From: [REDACTED]
Sent: 16 April 2018 15:36
To: Andrew Wood
Subject: Re: AW/45/18/HH - 19 Kingsway - spacial relationships and CA Statement.

From: Andrew Wood
Sent: Monday, April 16, 2018 1:31 PM
To: [REDACTED]
Subject: RE: AW/45/18/HH - 19 Kingsway

sheet 3 of 5

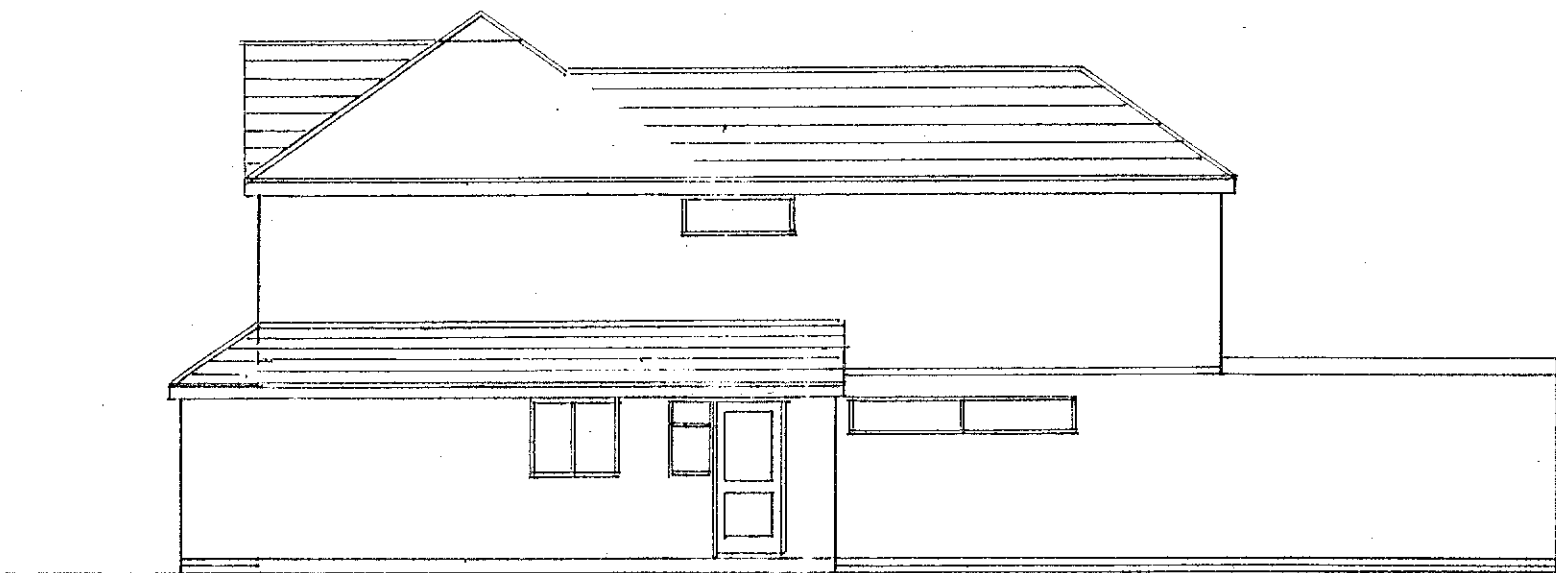
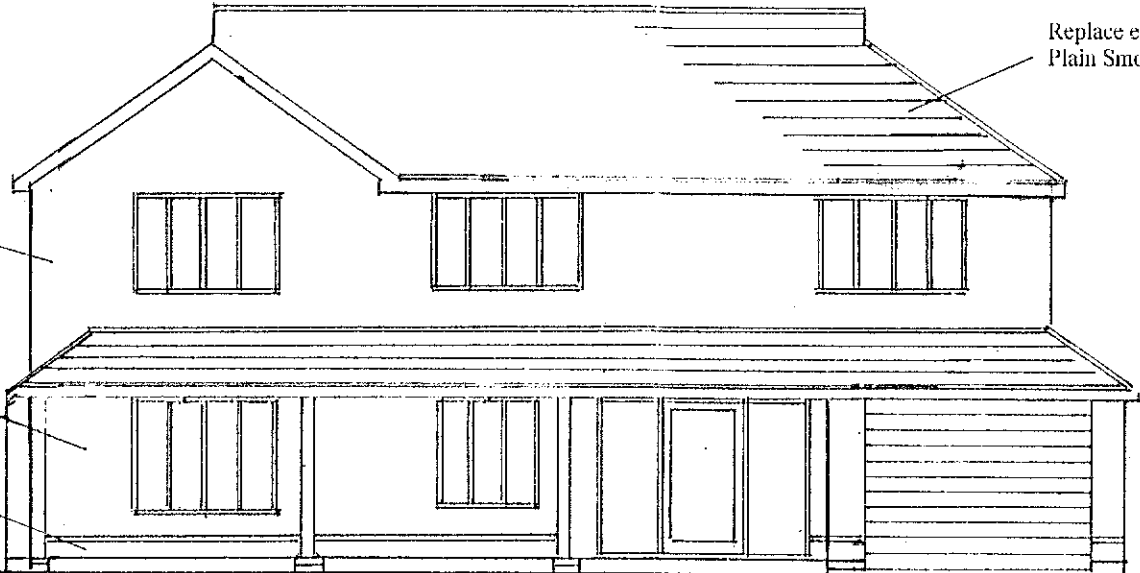
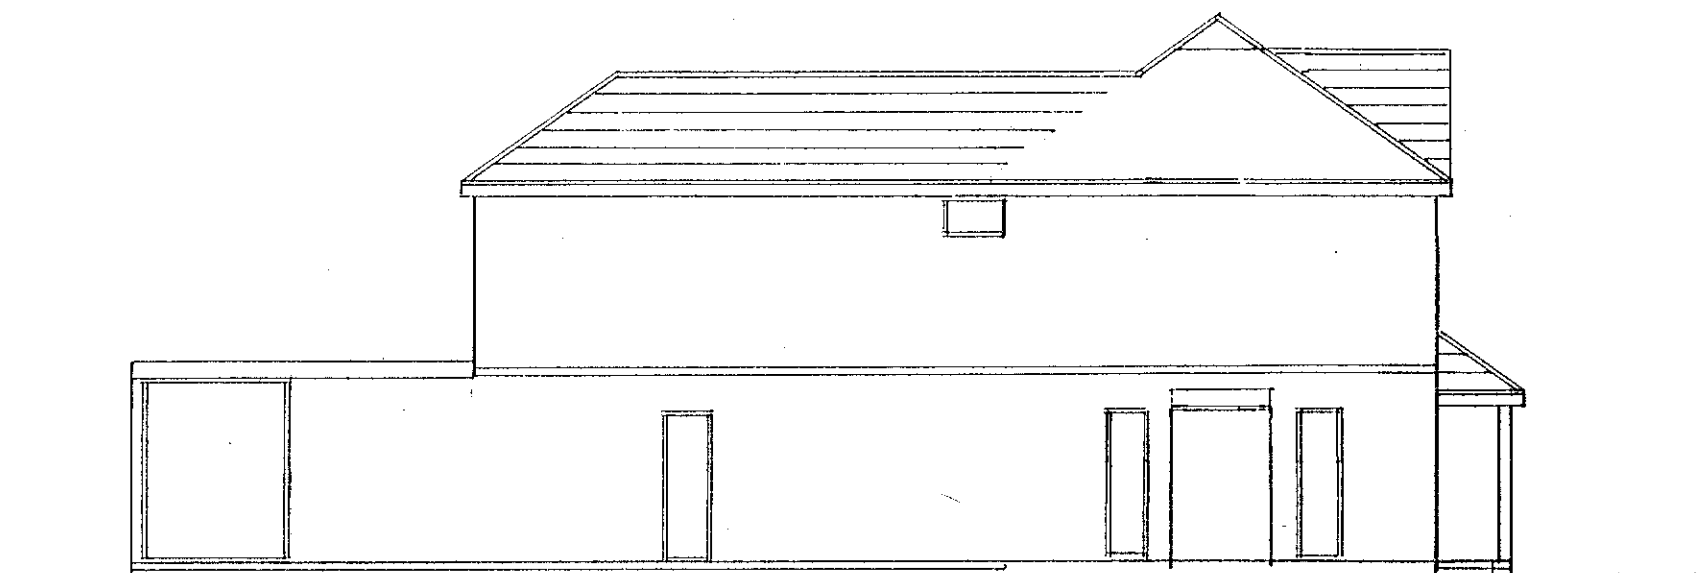
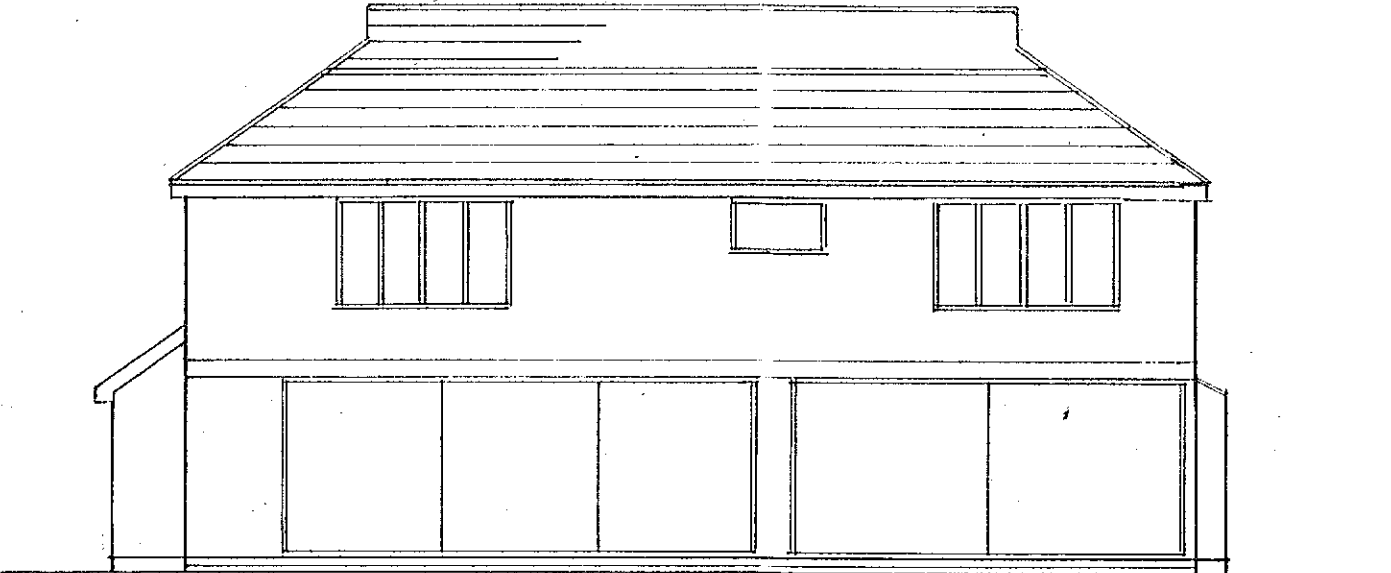
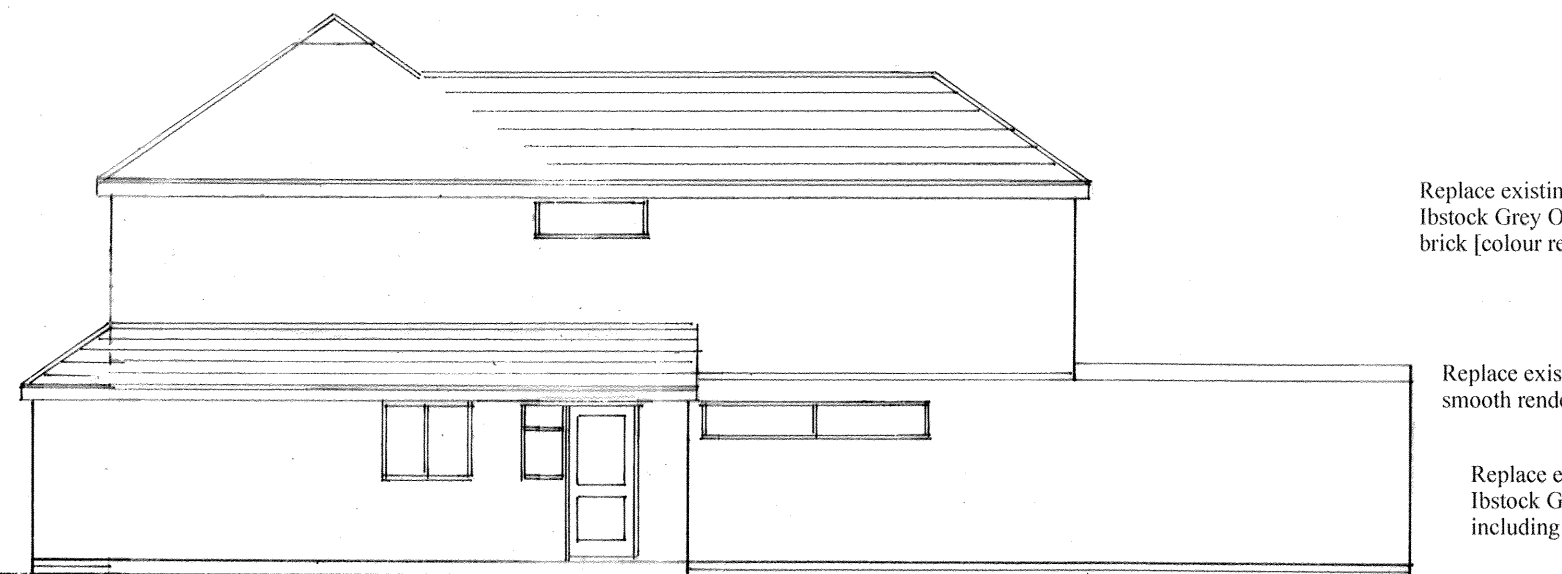
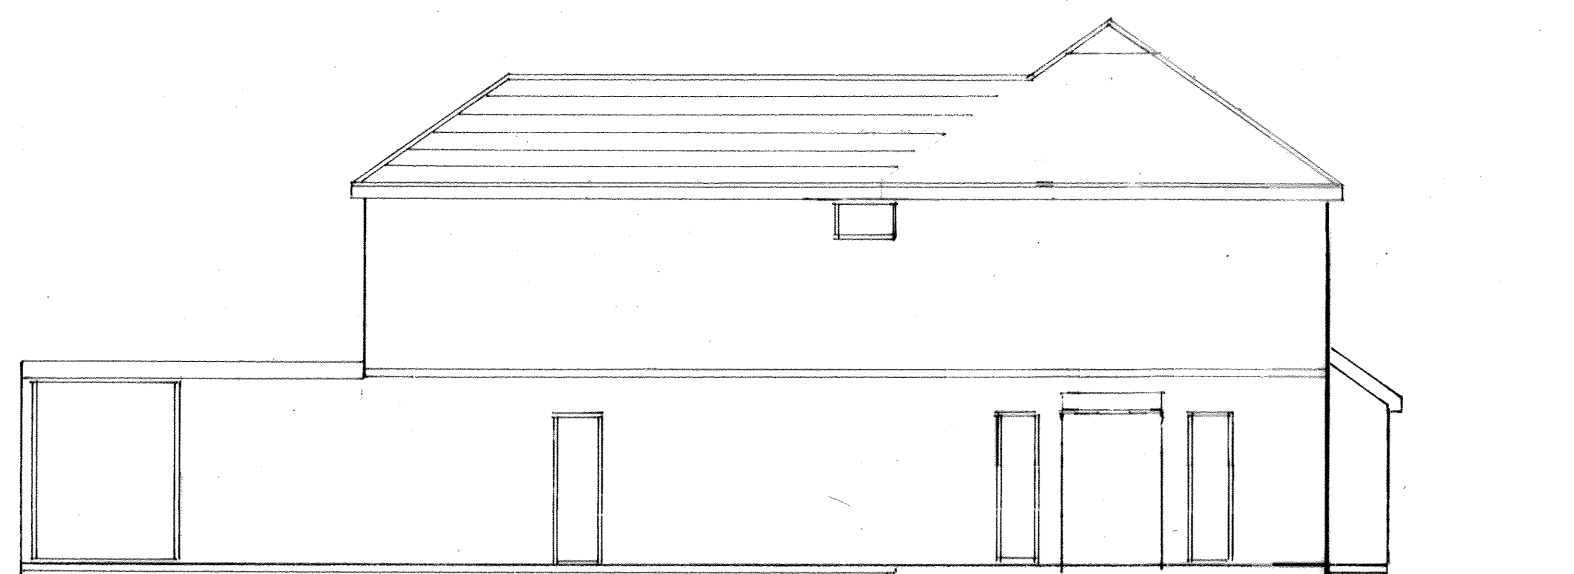
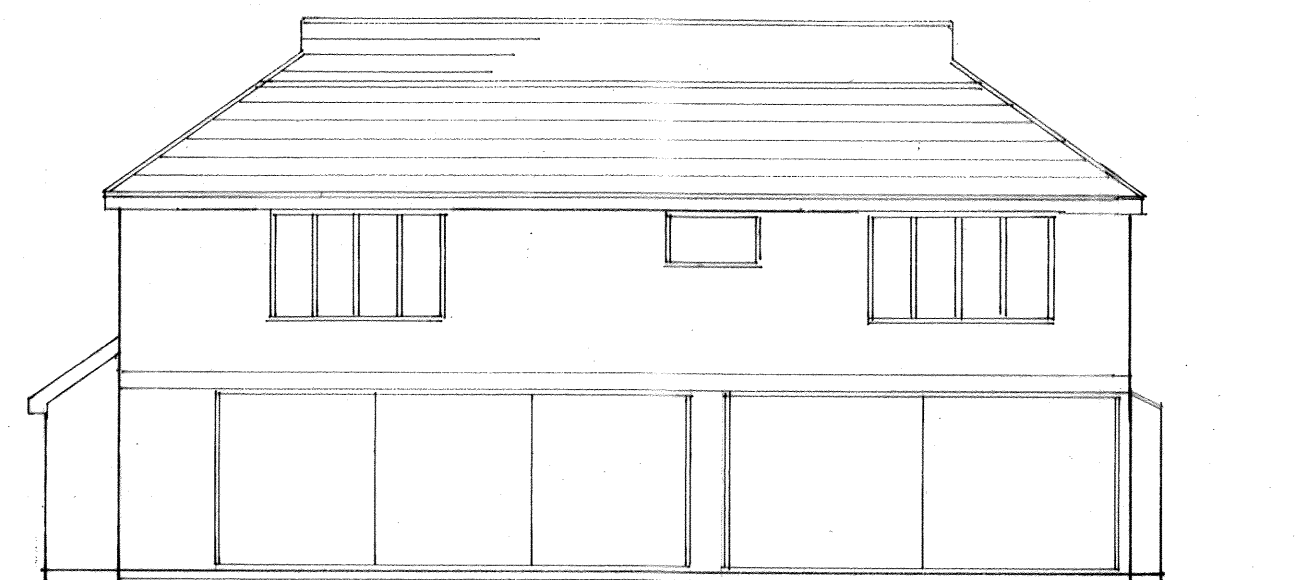
Amended plans have been submitted which retain the current roof shape, use red clay roof tiles and red brick at first floor level as well as removing the overhanging veranda on the front elevation at ground floor level. This was based on suggested amendments by the Conservation Officer. These are considered to improve the scheme and further public consultation is not considered necessary.
